RFI

RFI #: 98
Date: 3/29/2012
Job: EB-02 Keller Springs Lofts
Phone: 877-777-5115

Subject: B1 HC Floorplan

Drawing: S2.5 & A2.6HC
Cost Impact: None

2.6HC

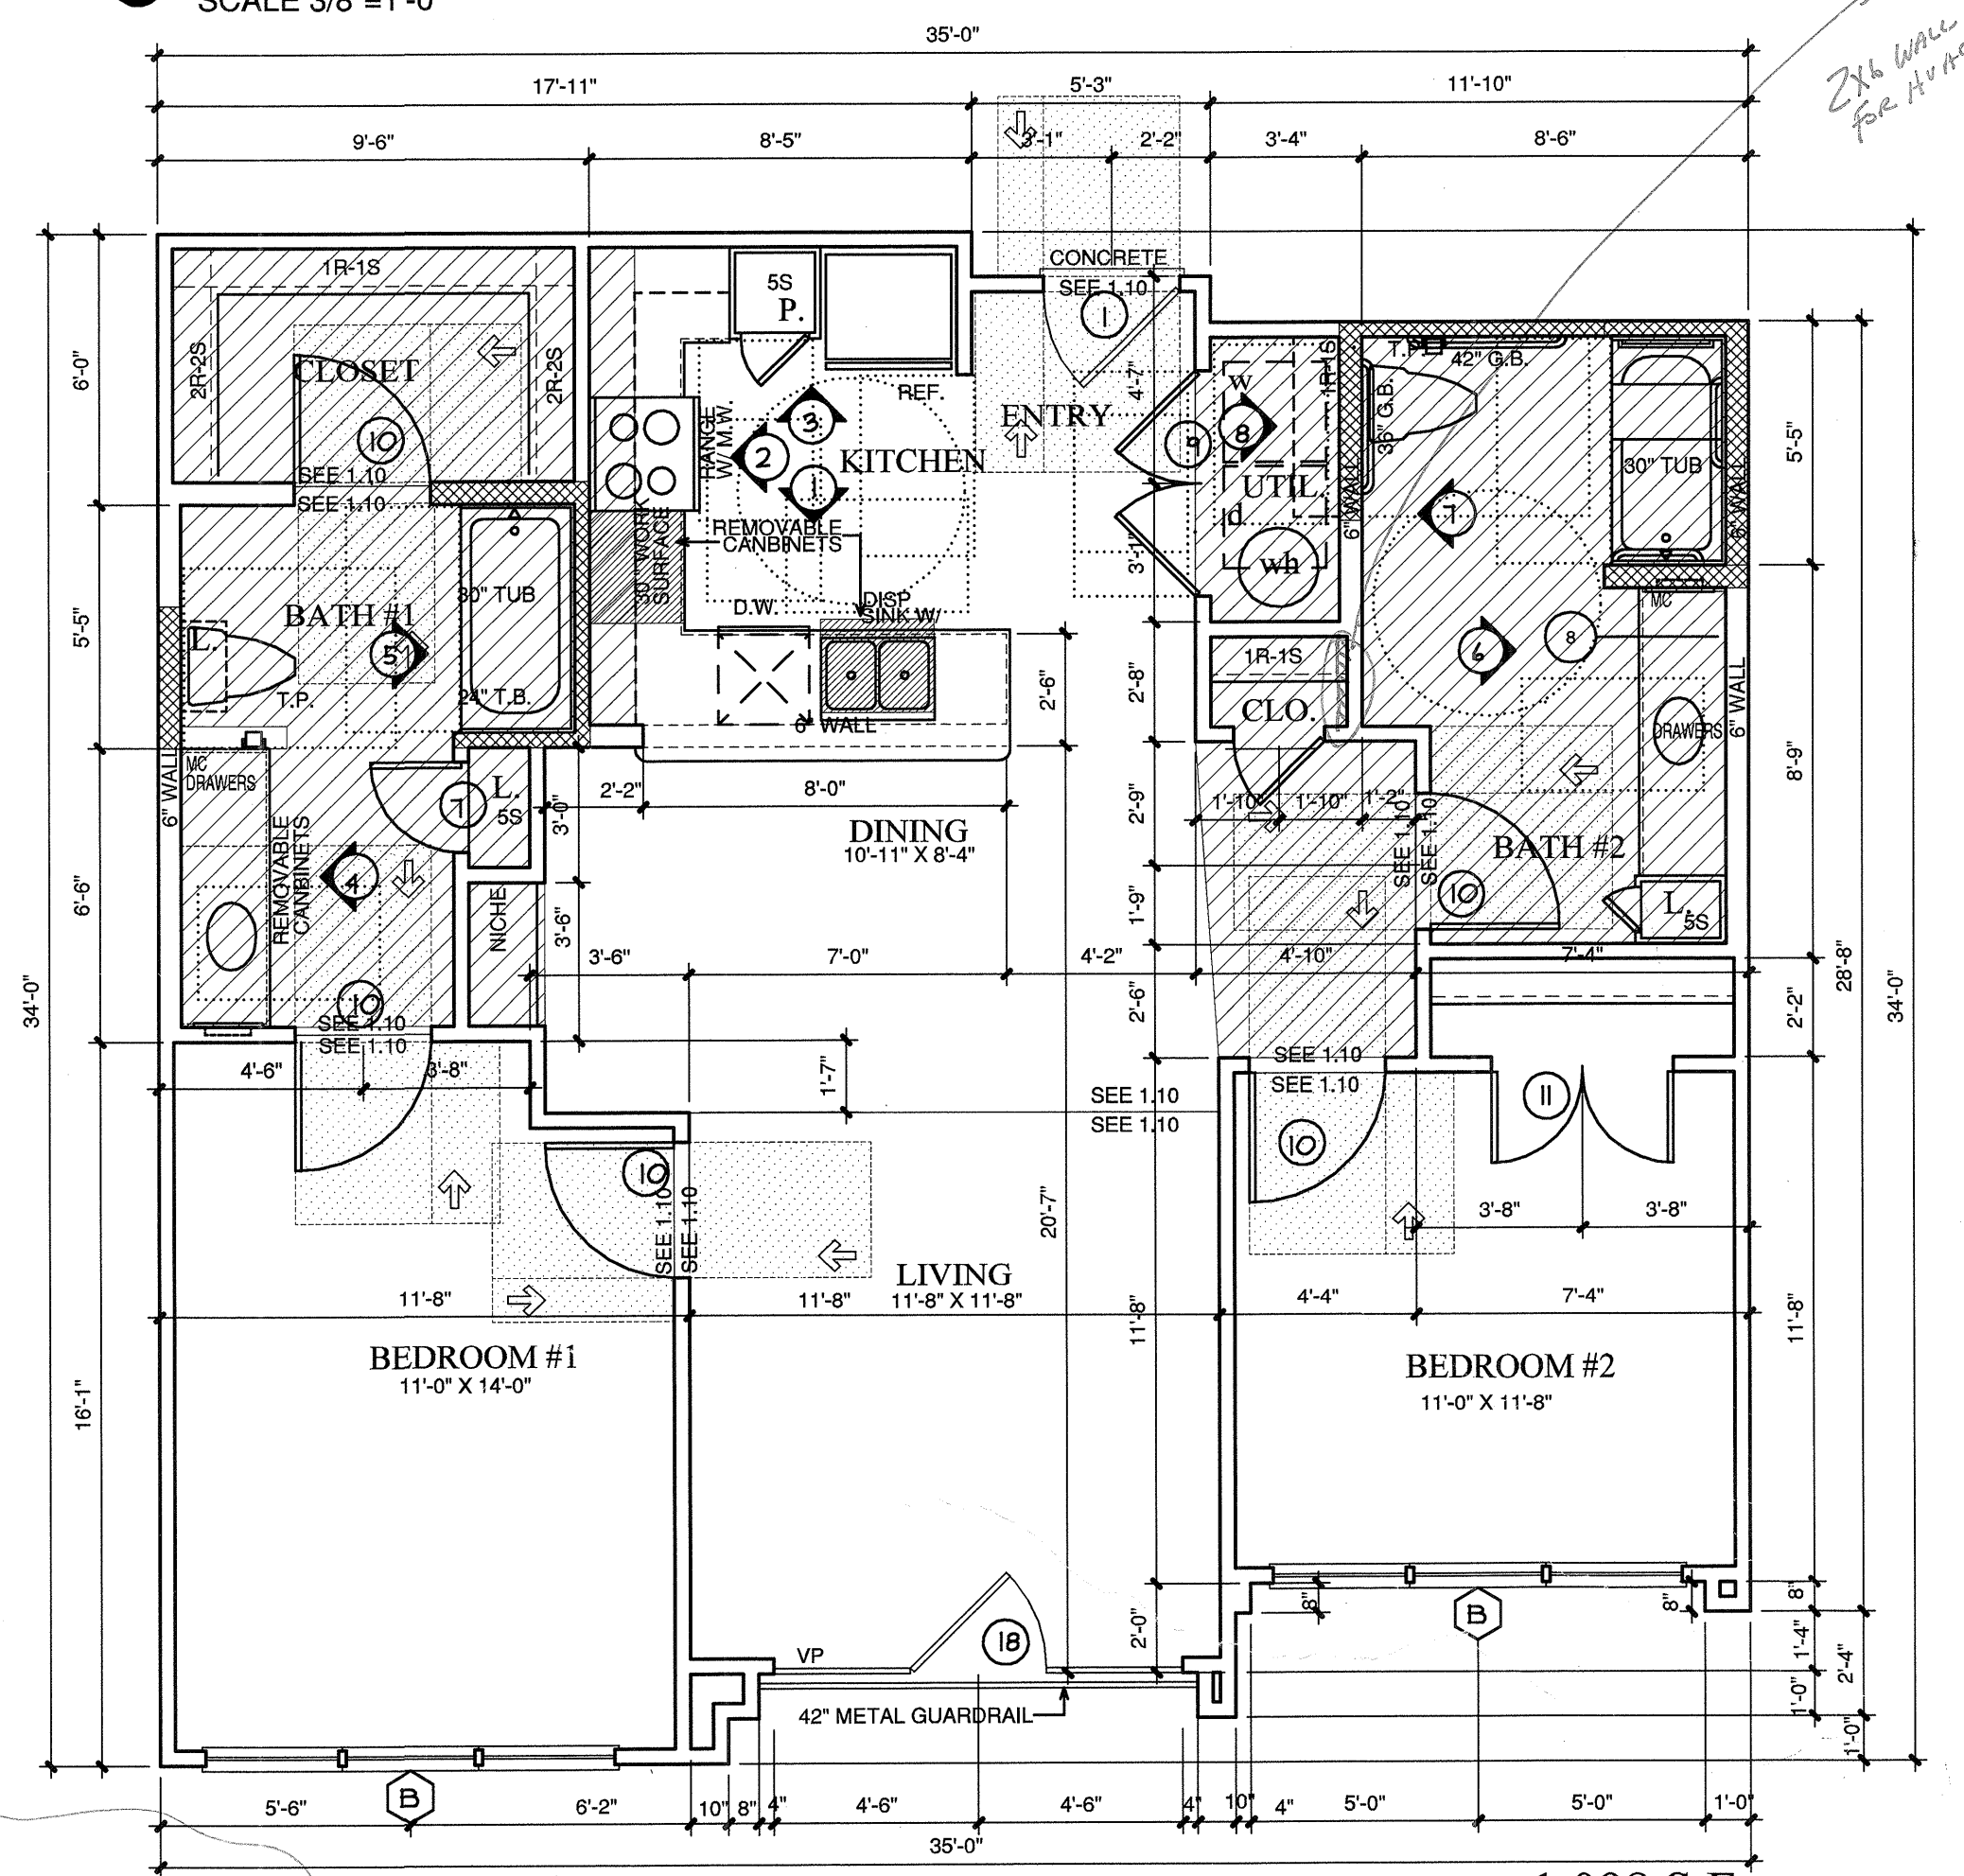
Request: Date Required: 4/6/2012
The floorplan shown for the B1HC unit on S2.5 is different from the floorplan shown on A2.6HC. Please let us know which is correct.

Architectural Drawings take precedent. Please verify with BGO that A2.6HC is correct.
R. Trent Perkins, P.E. June 14, 2012
Parkin-Perkins-Olsen Consulting Engineering, Inc.
